Albuquerque
Metropolitan
Arroyo
Flood
Control
Authority

October 24, 2012

Re: Grading & Drainage Plan for La Vista at Desert Ridge, ZAP C-19
Engineering Stamp Dated 10-18-12

City Project No. XXXXXX Zone Map No. C-19-Z Sheet 1 Of 1

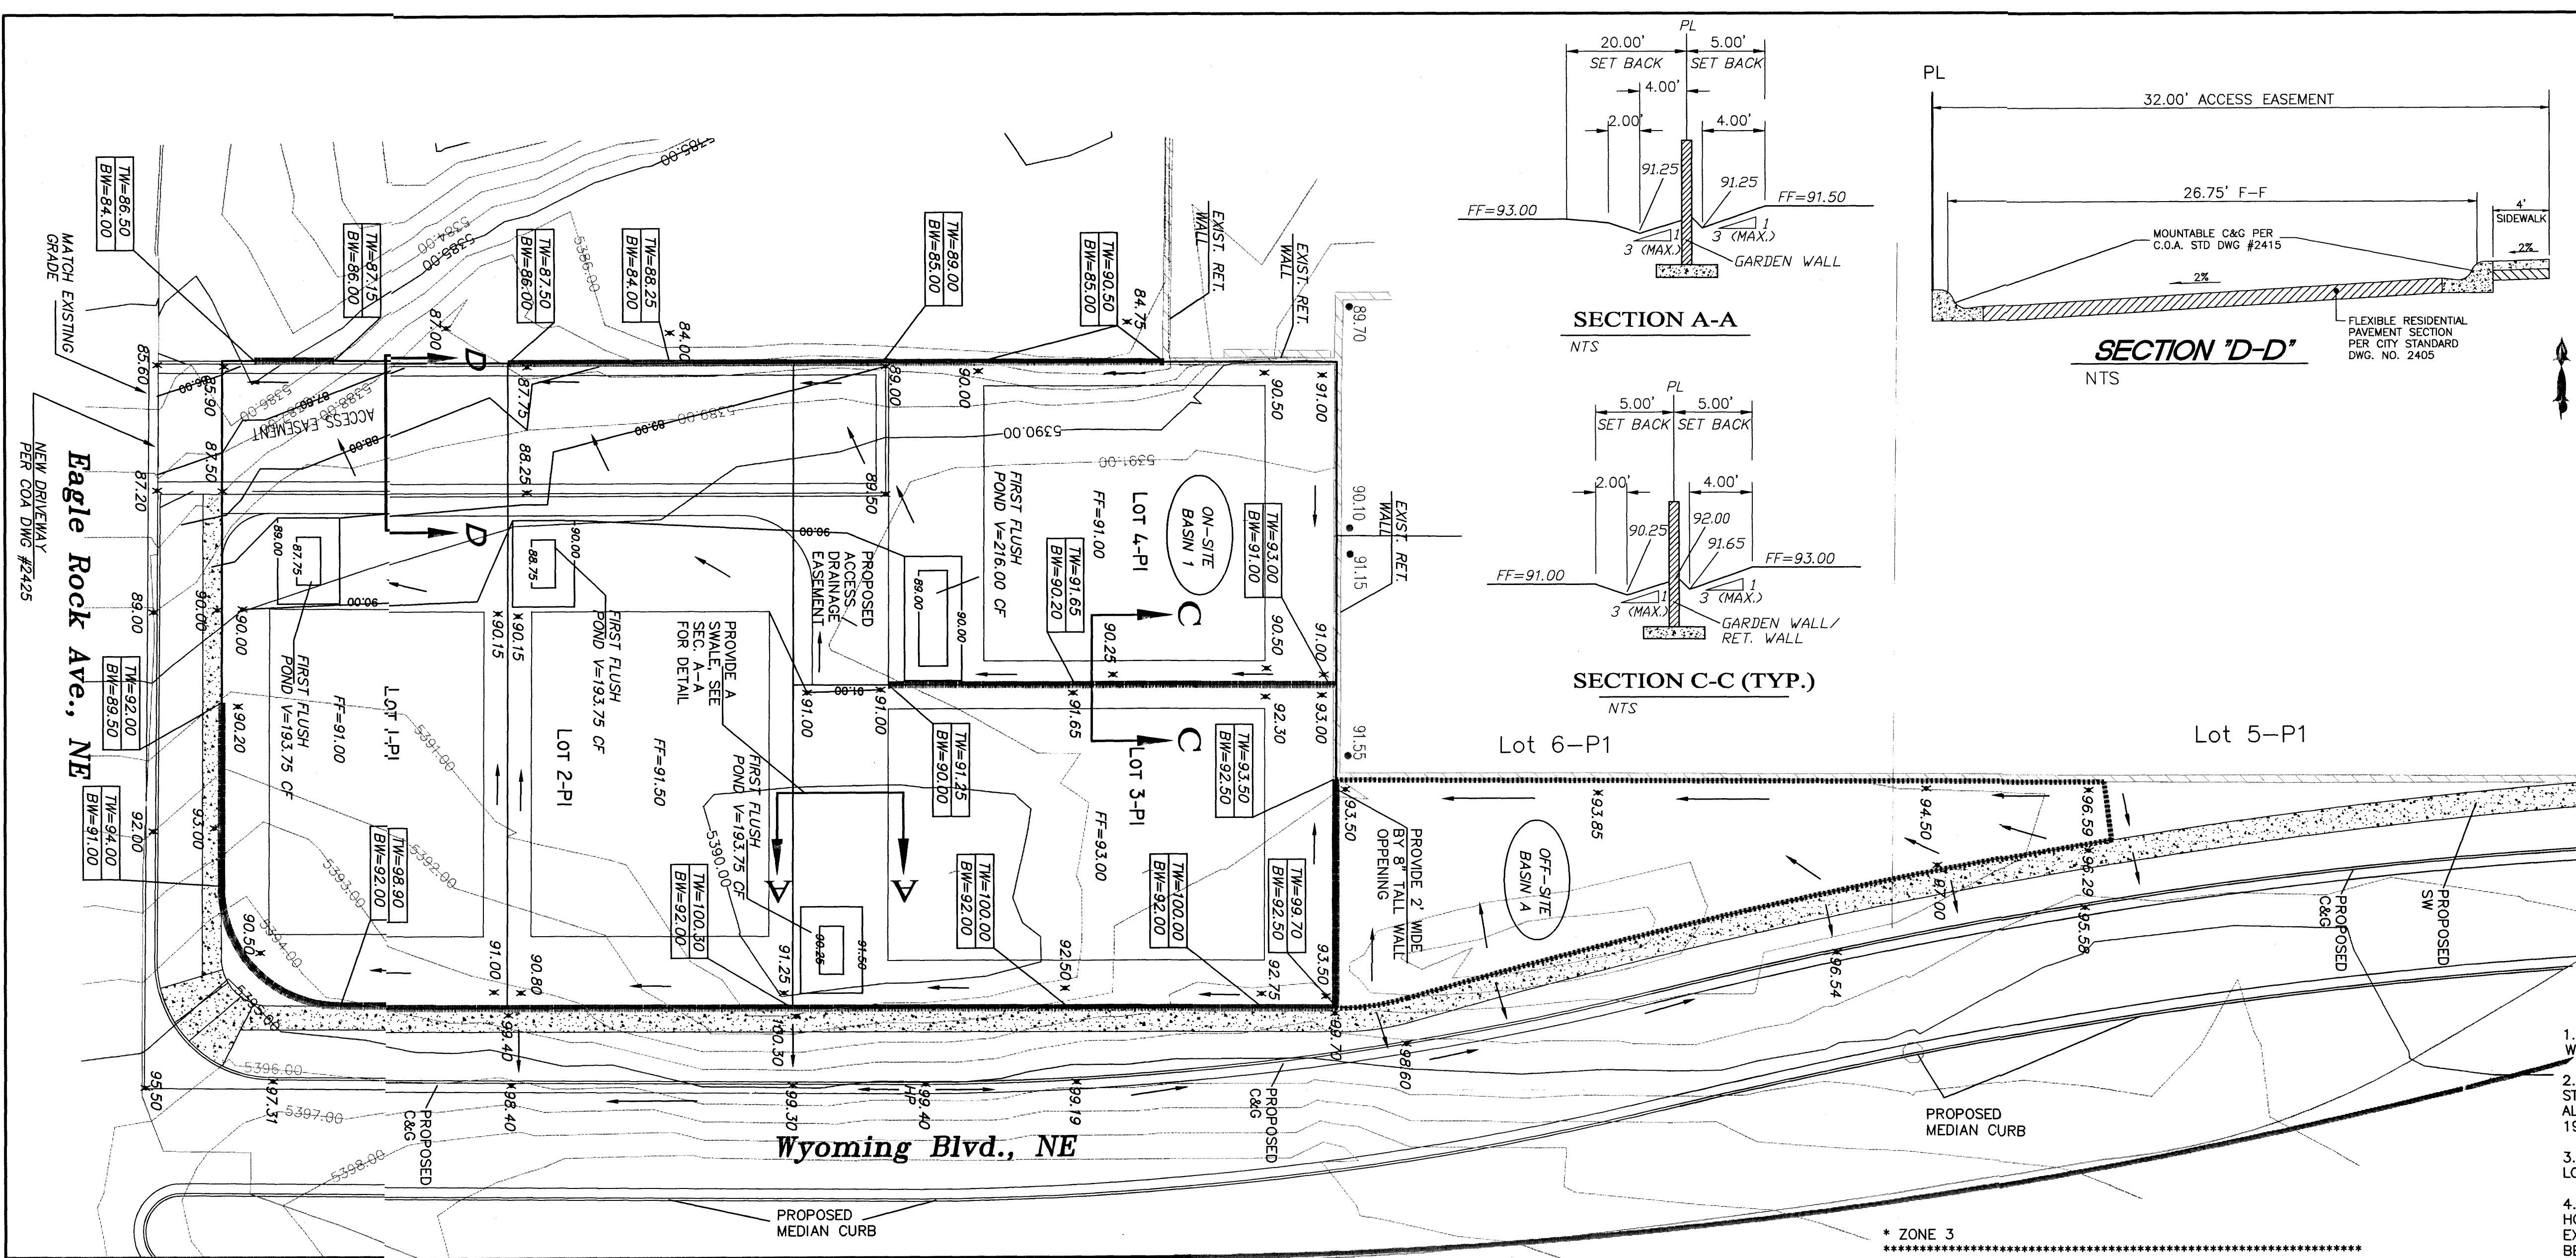
1. Show access for Lot 9C.
2. AMAFCA has had erosion problems from wall openings allowing discharge directly to its rights-of-way. Therefore, we no longer allow wall openings next to our property. Lots must be graded to a street. If this is not possible, provide a PVC drain pipe in the lot with a beehive grate to drain under wall. The pipe can daylight in AMAFCA's right-of-way with a riprap pad connection to the concrete rundown.
